EL PASO COUNTY GRADING AND EROSION CONTROL PLAN CHECKLIST

SHEET NO.
CE1.1

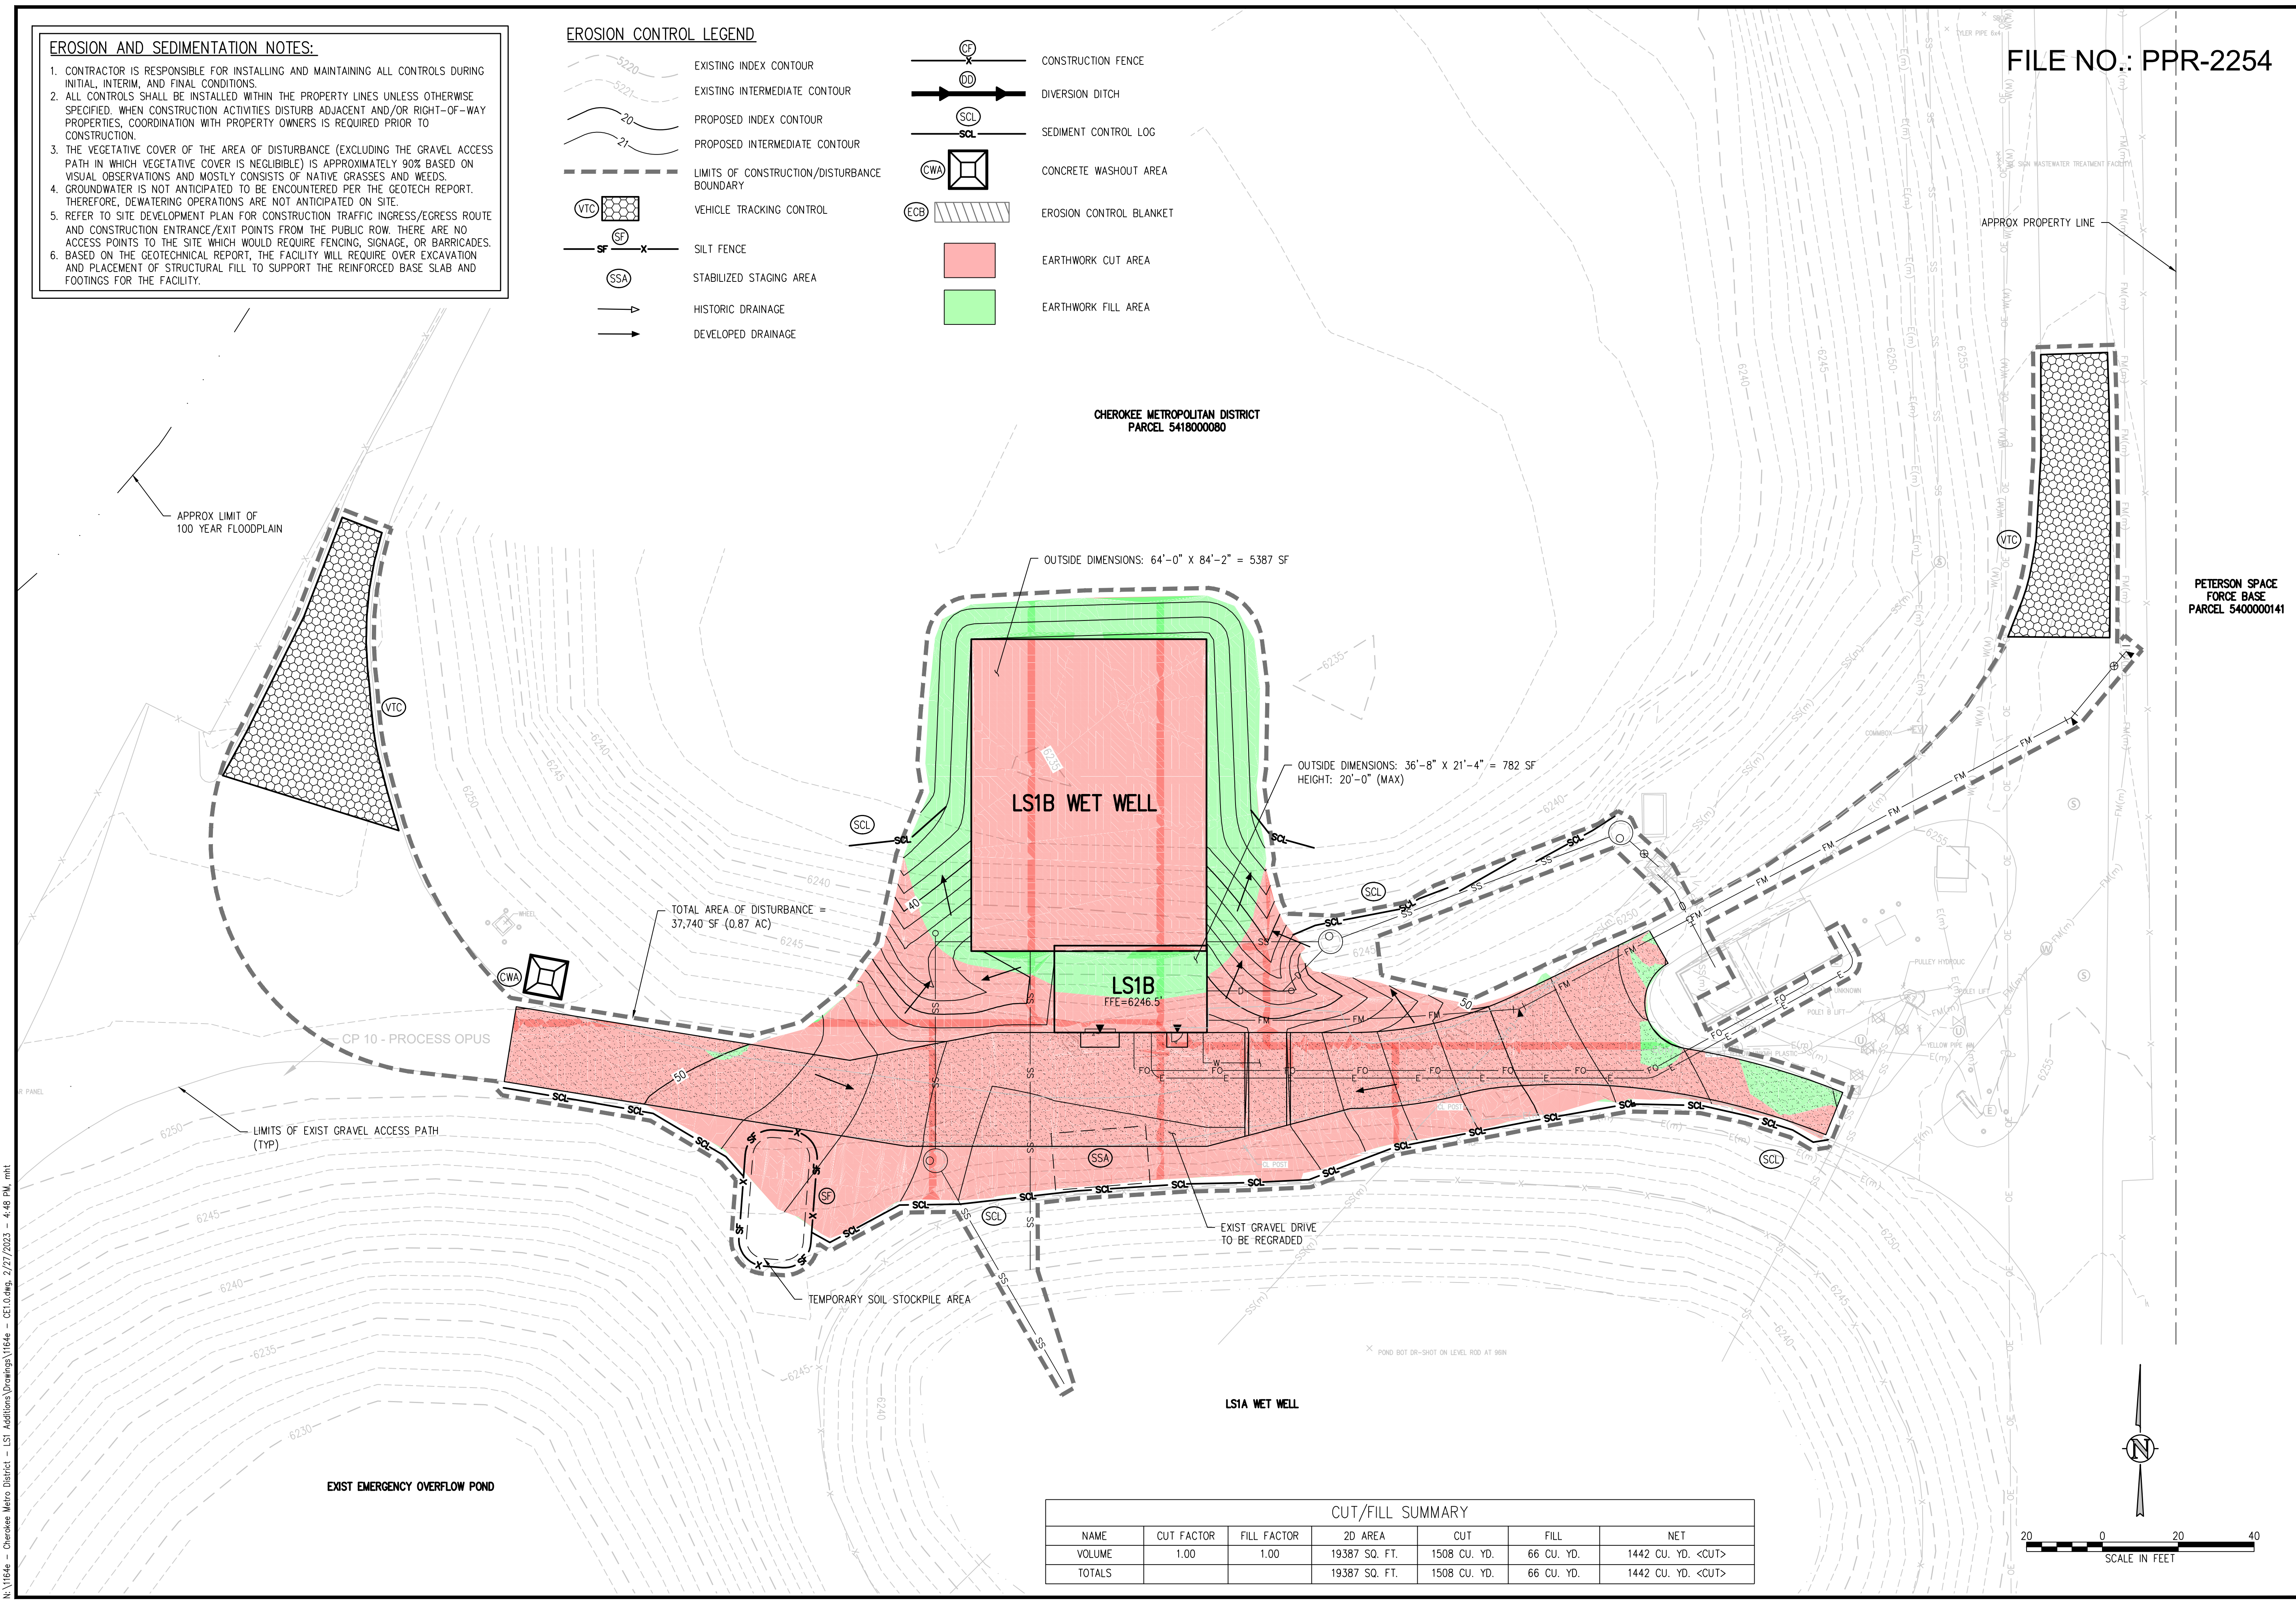
v	All proposed temporary construction control measures, structural and non-structural. Temporary construction control measures shall be identified by phase of implementation to include "initial," "interim," and "final" or shown on separate phased maps identifying each phase		✗
w	Vehicle tracking provided at all construction entrances/exits. Construction fencing, barricades, and/or signage provided at access points not to be used for construction		✗
x	Temporary sediment ponds provided for disturbed drainage areas greater than 1 acre		N/A
